MMO Reference: DCO/2022/00007
Planning Inspectorate Reference: EN010125
Registration Identification Reference: 20050160

Planning Act 2008, RWE Renewables UK Dogger Bank South (West) Ltd and RWE Renewables UK Dogger Bank South (East) Ltd, Proposed Dogger Bank South Offshore Wind Farms Order

Deadline 1 Submission – Summary of MMO Relevant Representation

Title:
MCZs within the Zol of the Projects

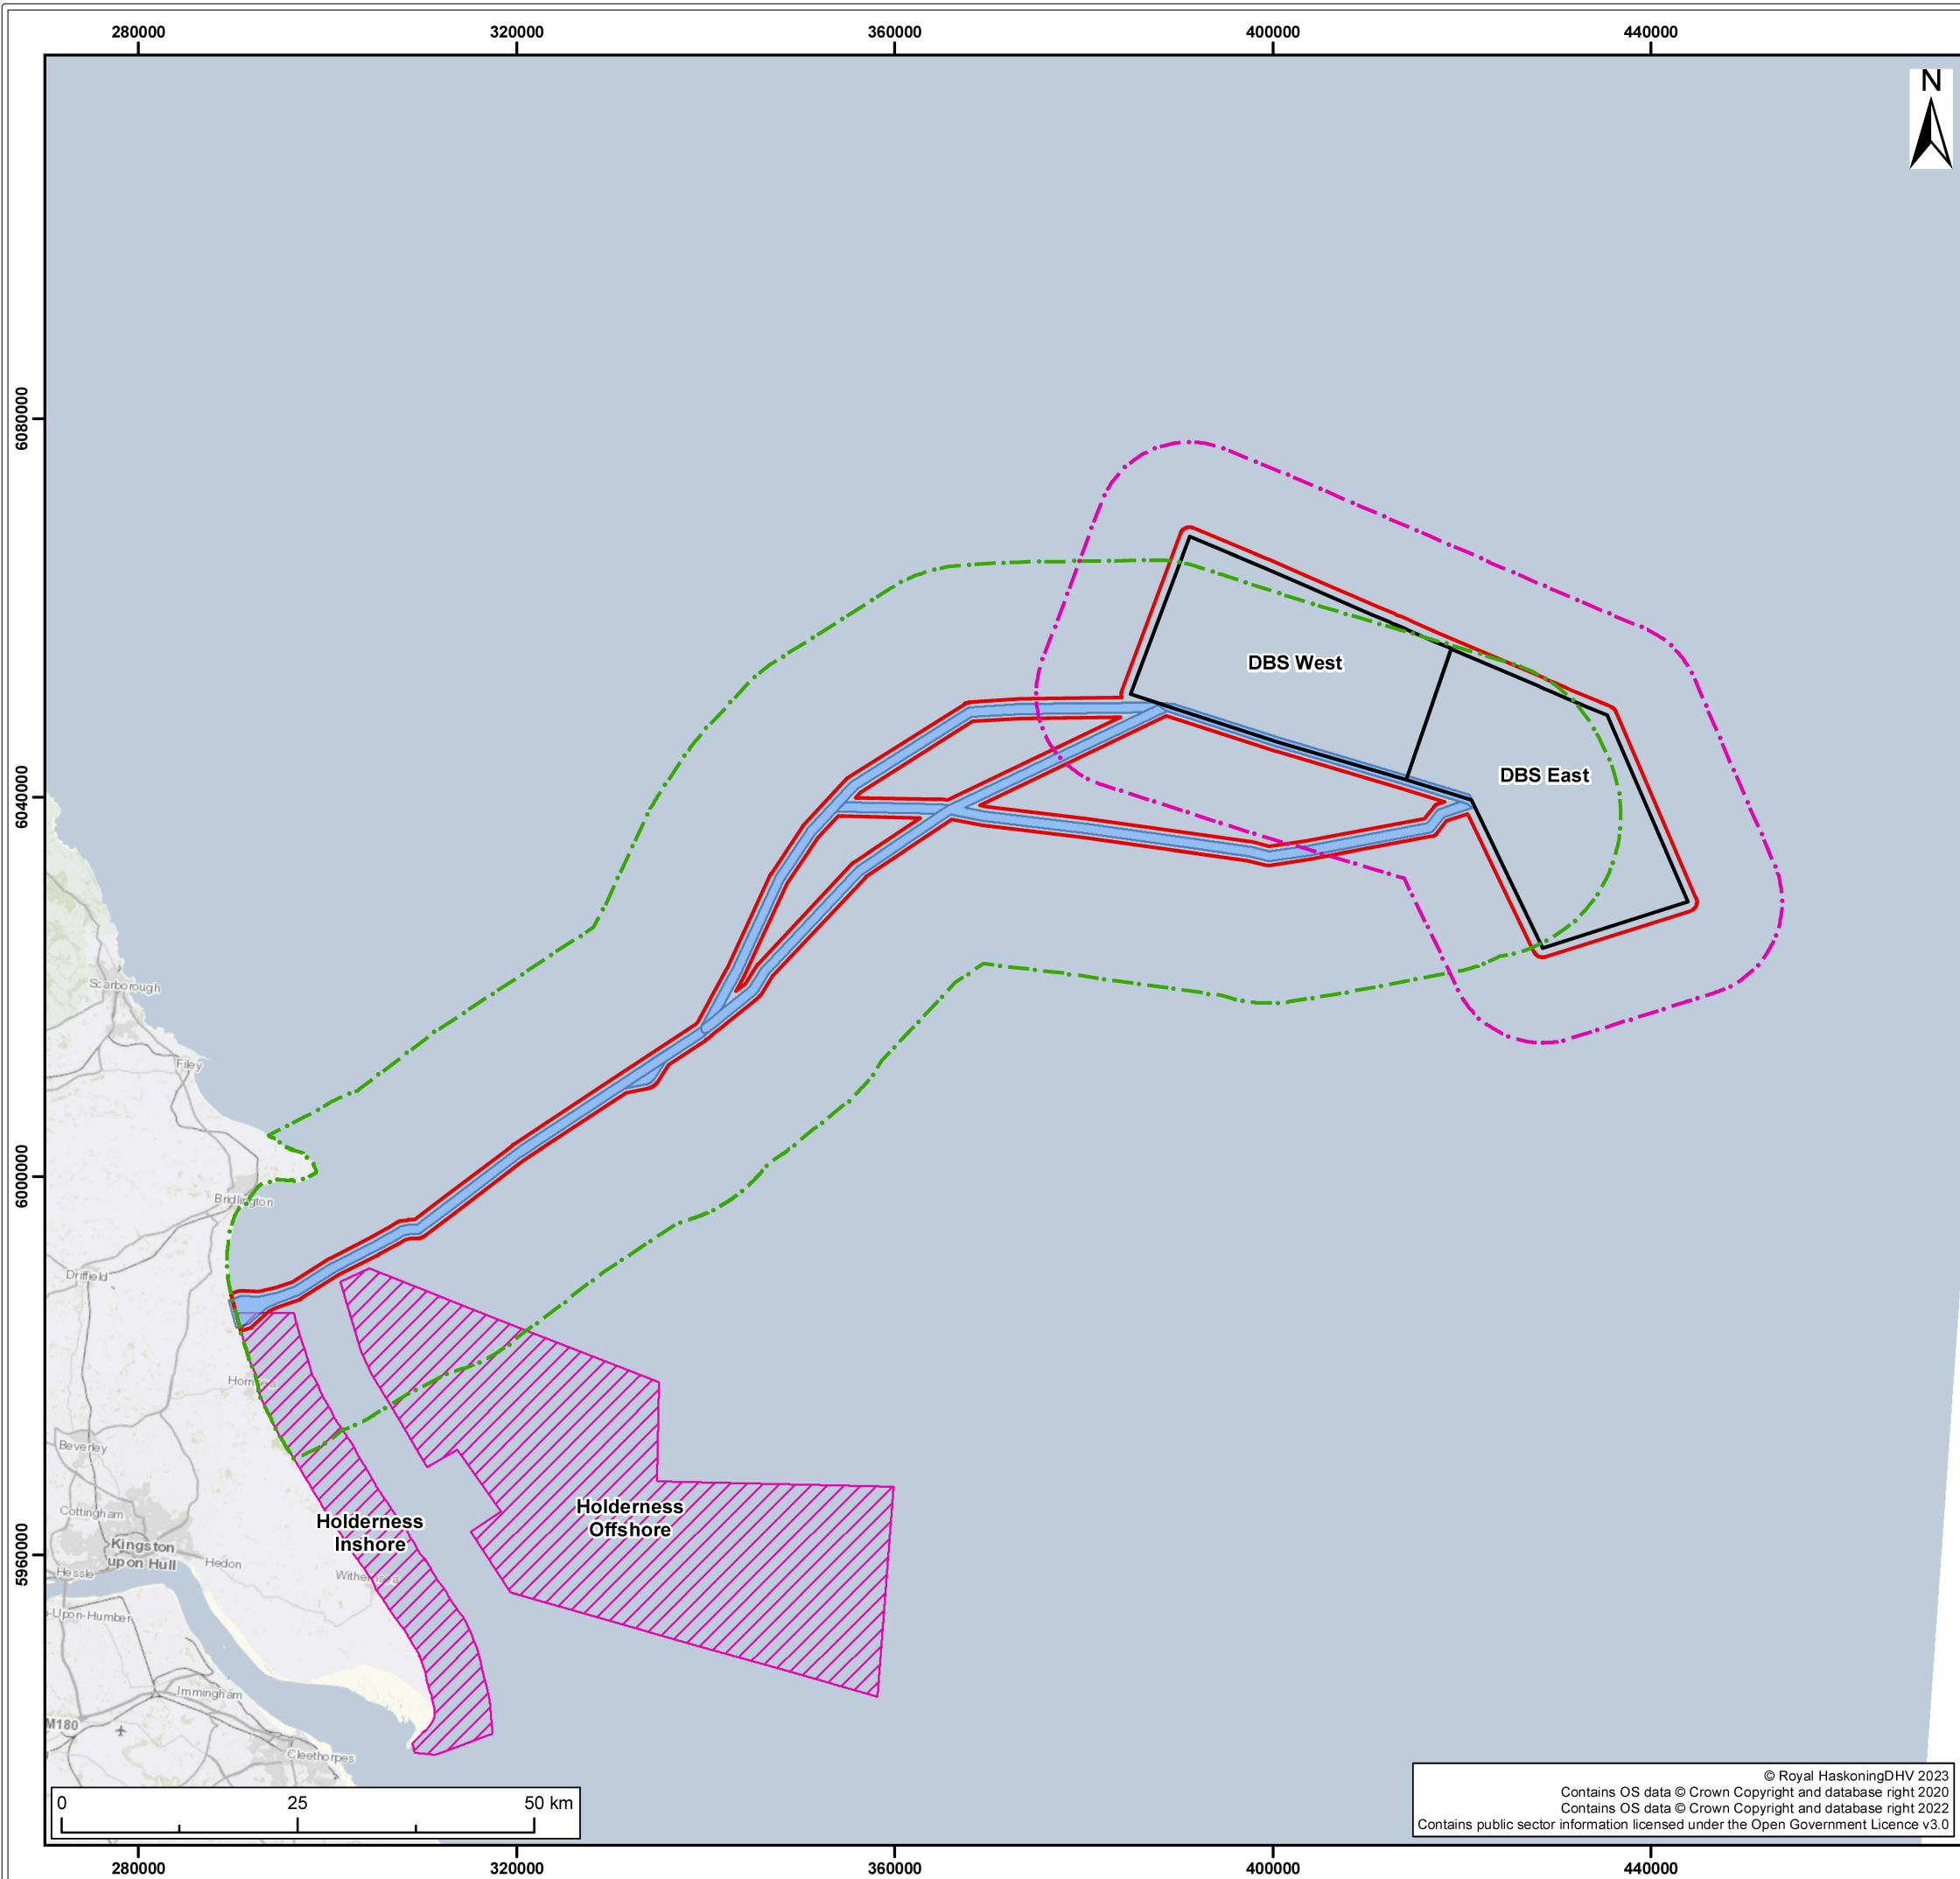
- 2.10.1. IPMP does not include MCZ monitoring and the MMO has concerns in relation to the Holderness Inshore MCZ. If anchoring events do happen in MCZ area, the MMO would expect that monitoring would be required.
- 2.10.2. The MMO requests updates to ensure commitment that first four piles monitored would be the worst-case scenario piles.
- 2.10.3. The MMO requires more information on timing of proposed surveys, the expectations, and the Applicant's intentions should the observations not meet the expectations.
